REQUEST

Current Zoning: NS (neighborhood services)
Proposed Zoning: I-2(CD) (general industrial, conditional)

Approximately 9.84 acres located on the south side of Old Dowd Road at the intersection with Sam Wilson Road.

The petition proposes to allow 92,000 square feet of gross floor area of indoor self-storage as well as outdoor boat and RV parking and storage.

**CONCEPT PLAN - L-2**

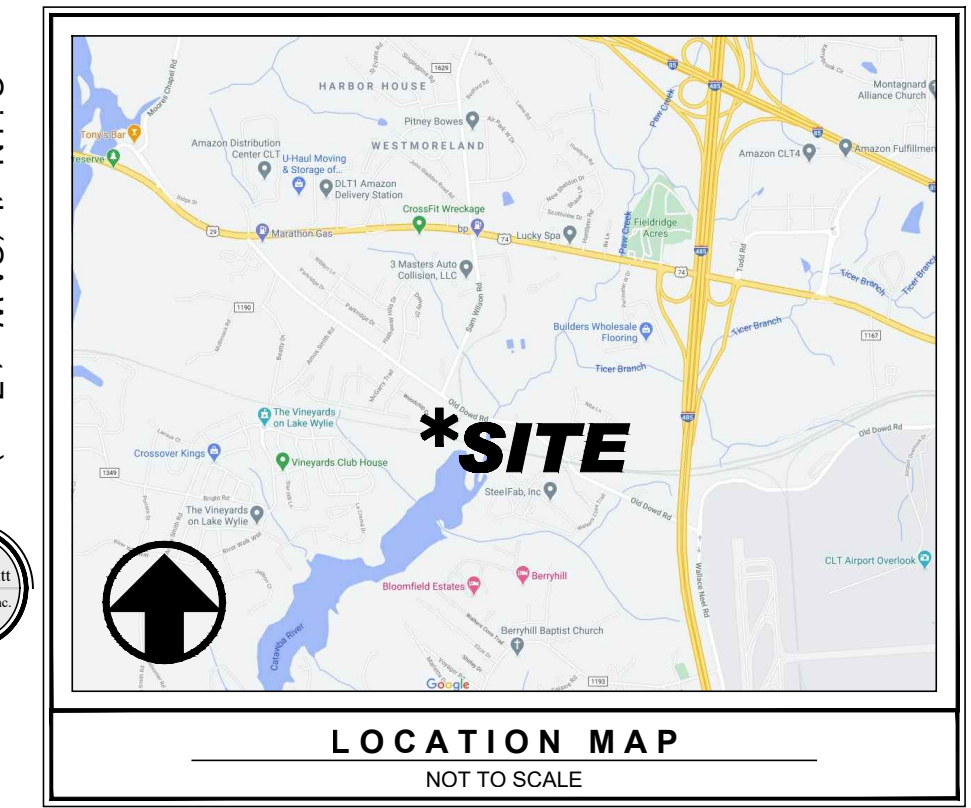
1. Revise the site plan to show a 6' sidewalk as is referenced in the conditional notes.
2. Add a conditional note to commit to connecting the traffic signal to the CDOT network via fiber optic connection.

4. Revise southbound approach laneage to thru-right lane with dedicated left turn lane. If the lane configuration remains right lane with thru-left the proposed driveway stem needs to match so the signal can run without split phase operation.

5. Add a conditional note committing to the right turn lane on Old Dowd Road shown on the site plan.
6. Extend the driveway stem into the site as is shown in CDOT's memo.

7. Please include the following note under Environmental Features: "Development within any SWIM/PCSO Buffer shall be coordinated with and subject to approval by Charlotte-Mecklenburg Storm Water Services and mitigated if required by City ordinance. Petitioner acknowledges intermittent/perennial stream delineation reports are subject to review and approval upon submission of development plans for permitting and are not approved with rezoning decisions. The existing pond on site may require a buffer depending on results of the delineation report."
8. Revise the buffer on the western property boundary to be a minimum of 100', which can be reduced to 75' with a berm.
